Our Ref: EN020028

Date: 18 November 2024

Application by Morgan Offshore Wind Limited and Morecambe Offshore Windfarm Limited for an Order Granting Development Consent for the Morgan and Morecambe Offshore Wind Farms Transmission Assets project

Advice following issue of decision to accept the application for examination

**Drawing Number:**  
BP-GBR-MORG-REG-0181

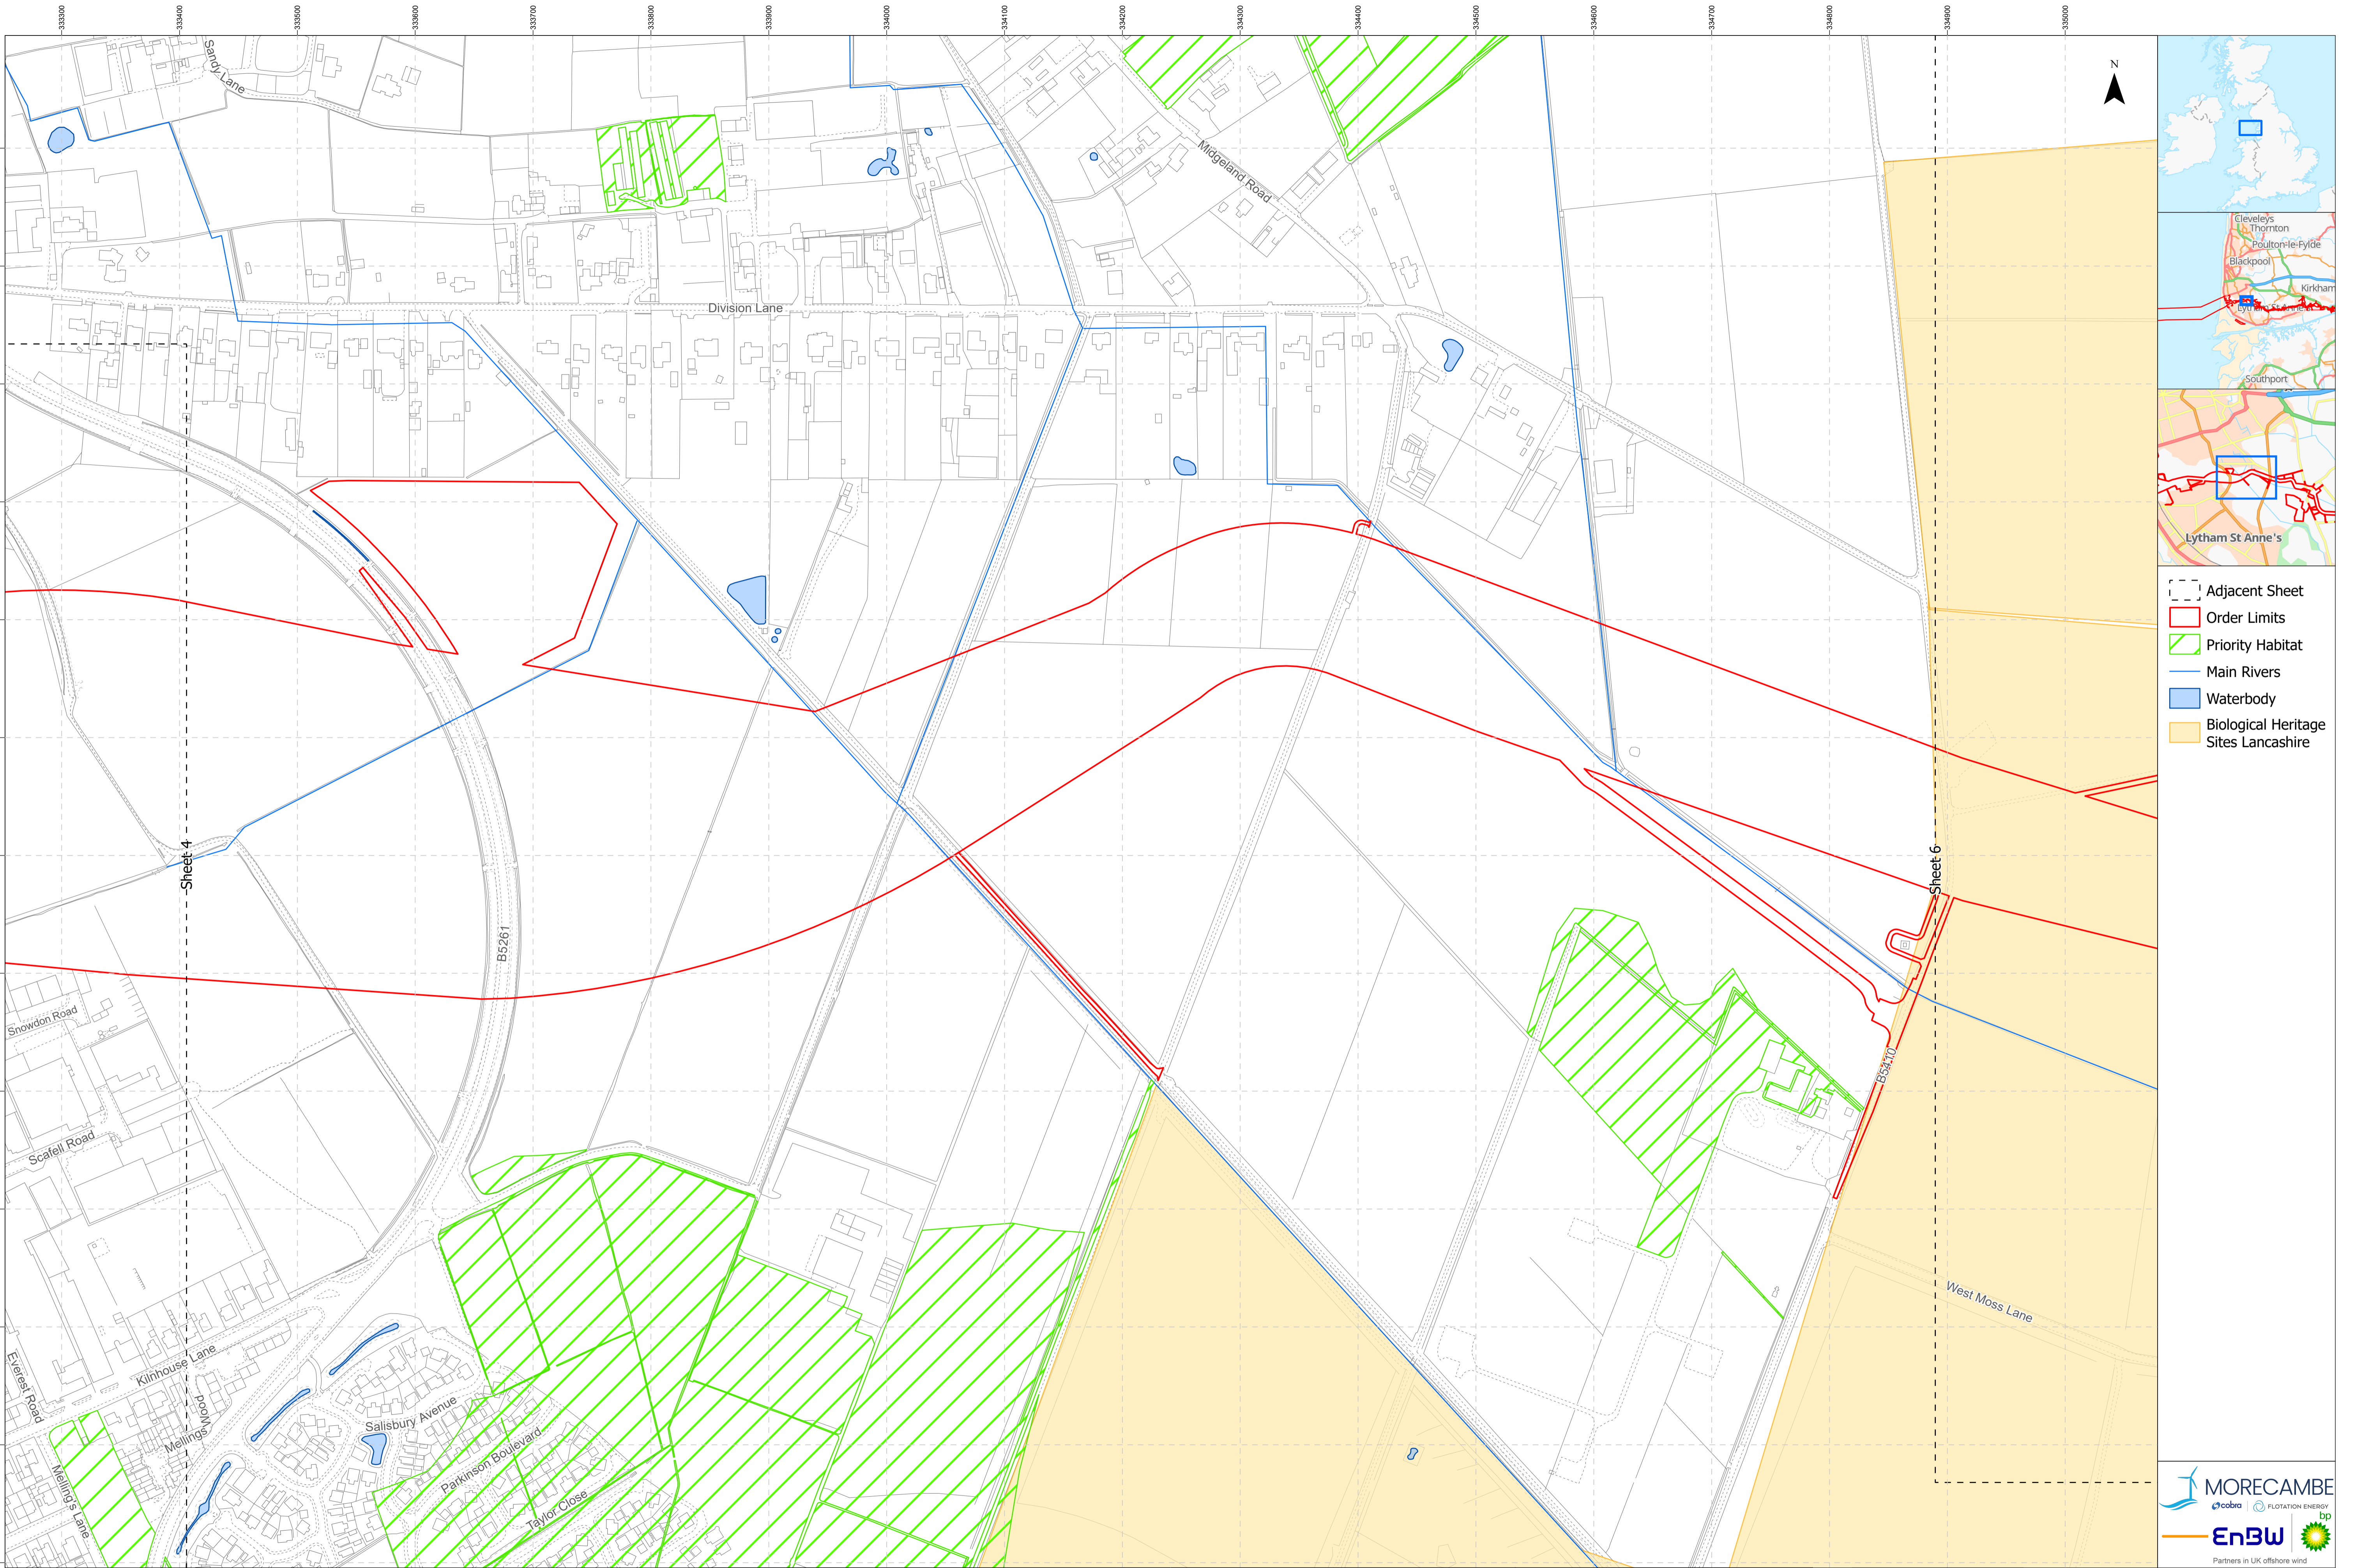
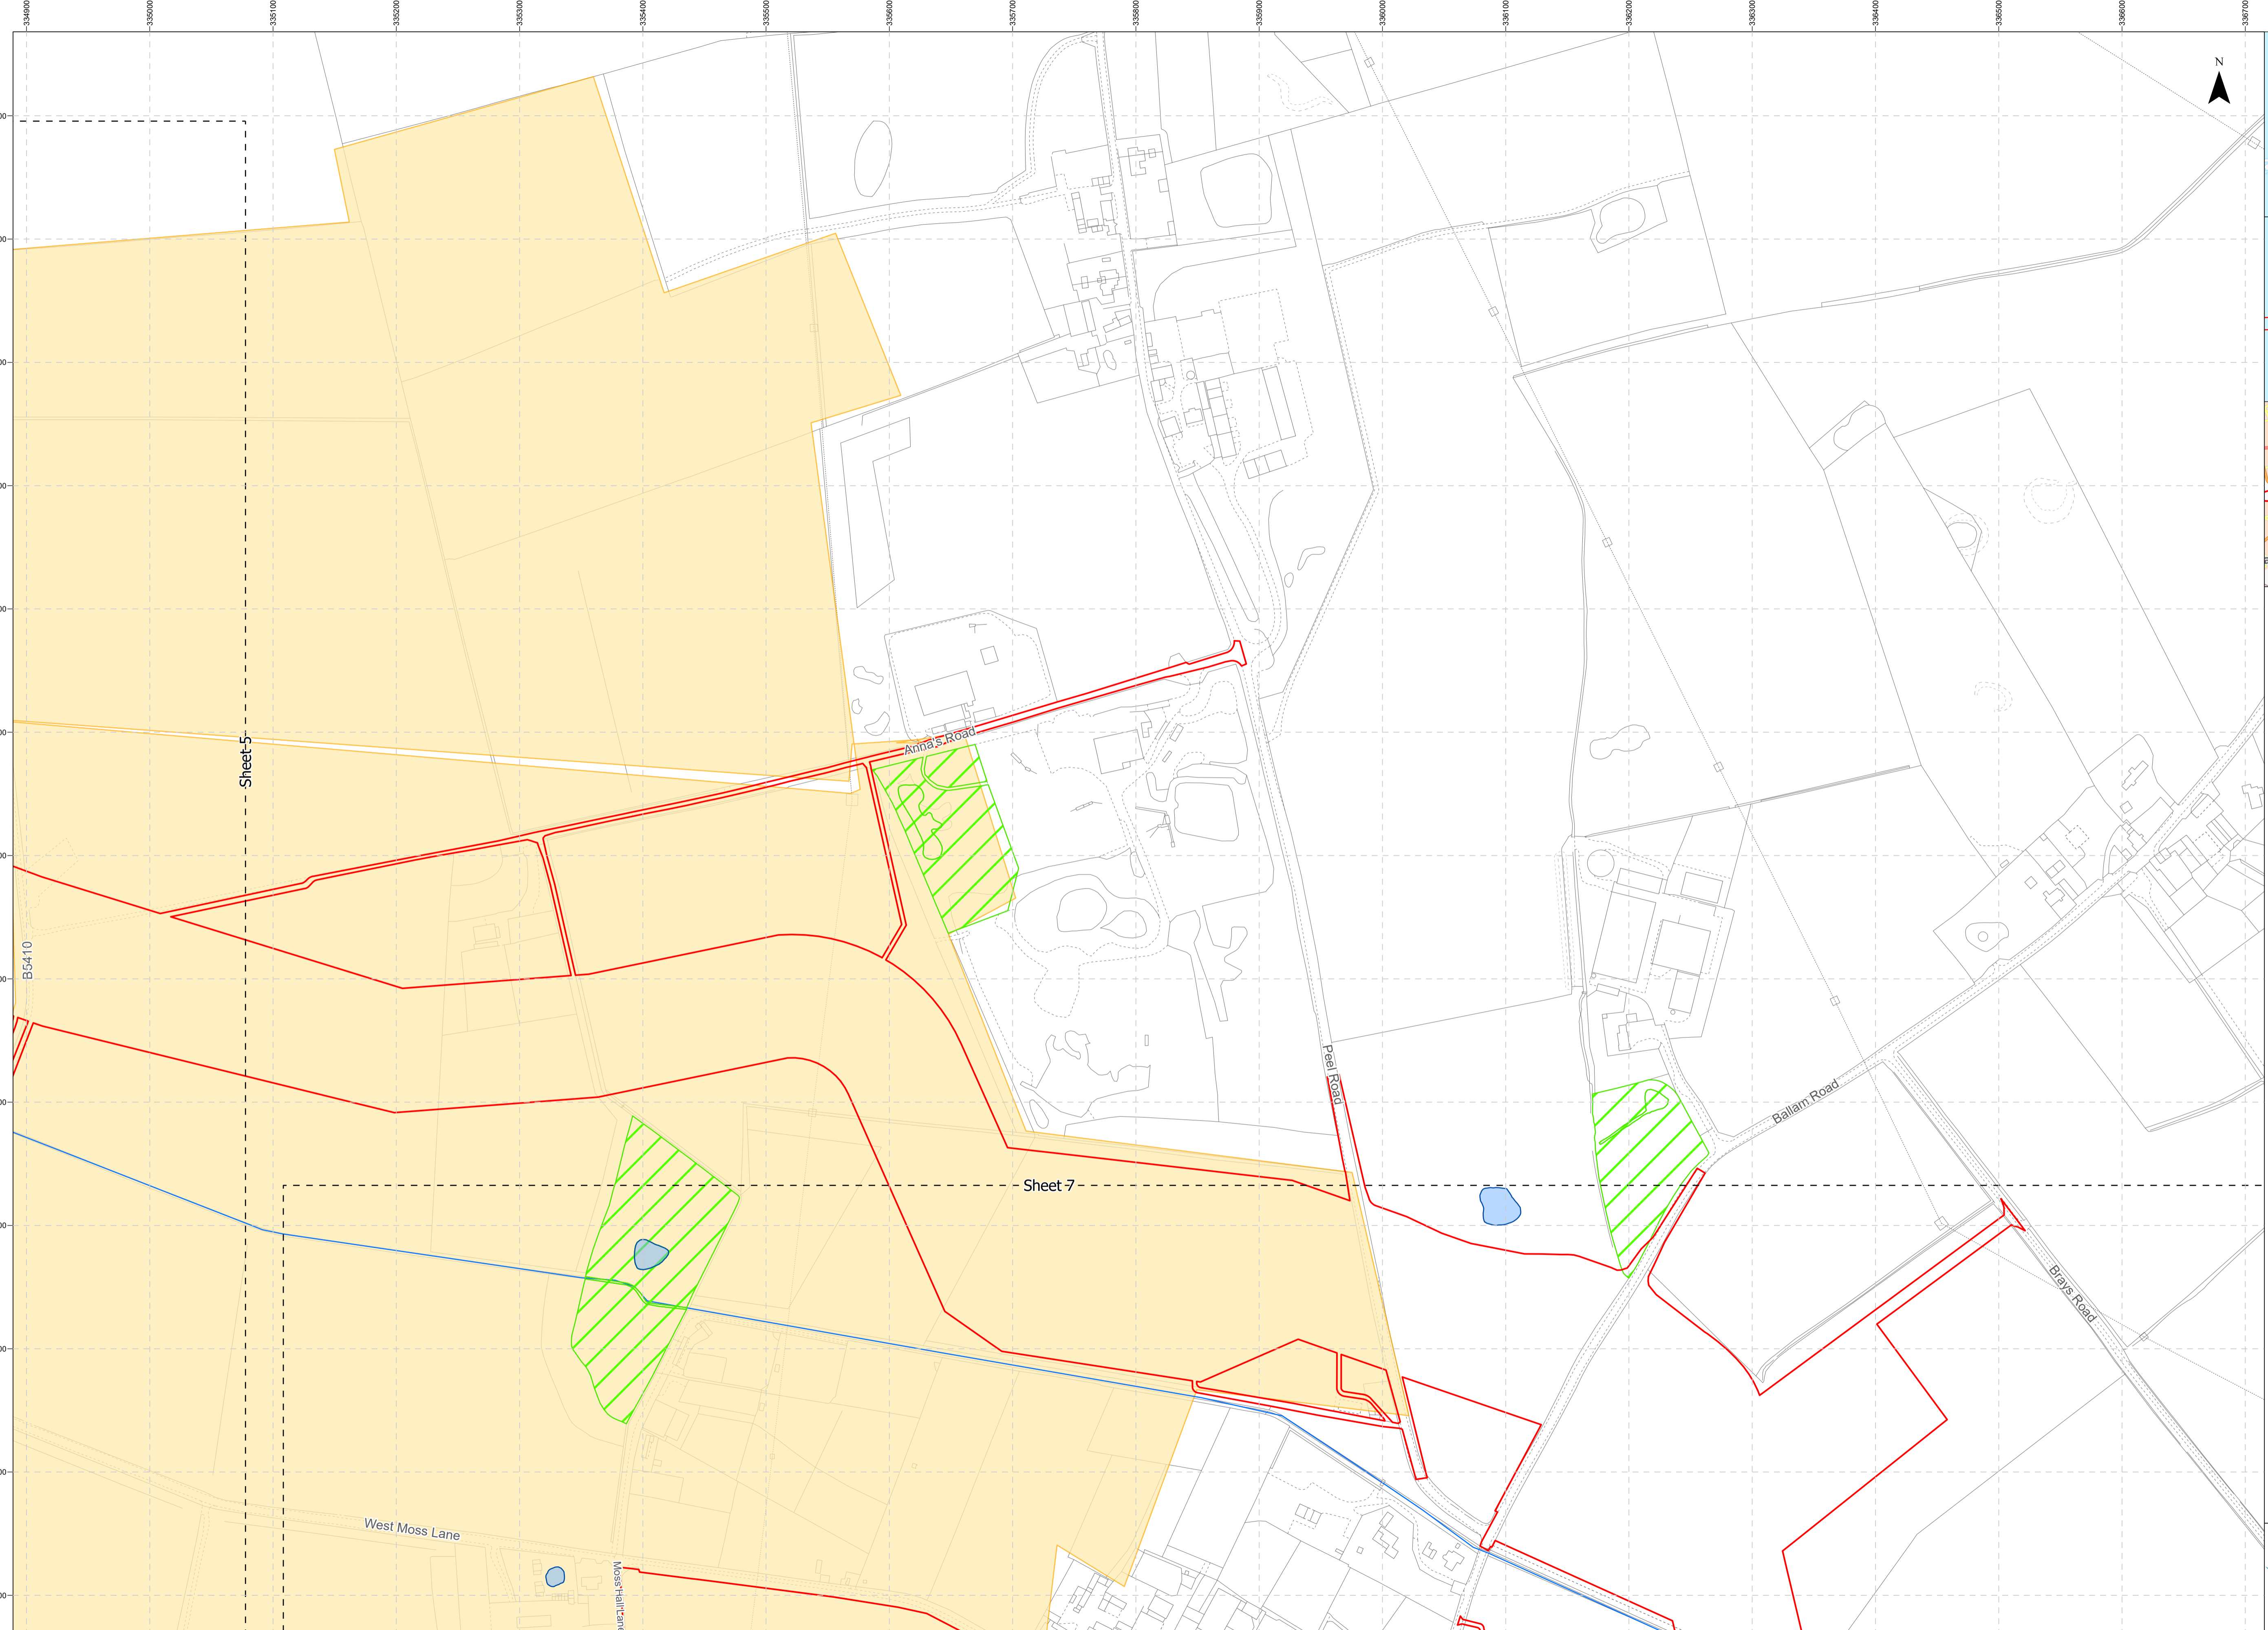
The plans showing Onshore Statutory and Non-Statutory Nature Sites (and Waterbodies in a River Basin Management Plan) (Doc B14) and Onshore Historic or Scheduled Monument Sites (Doc B16) present the sites, rivers or historic assets, however these are not labelled (unlike the equivalent offshore plans). The Applicants are advised to provide an updated set of figures with appropriate labelling of the features being represented.
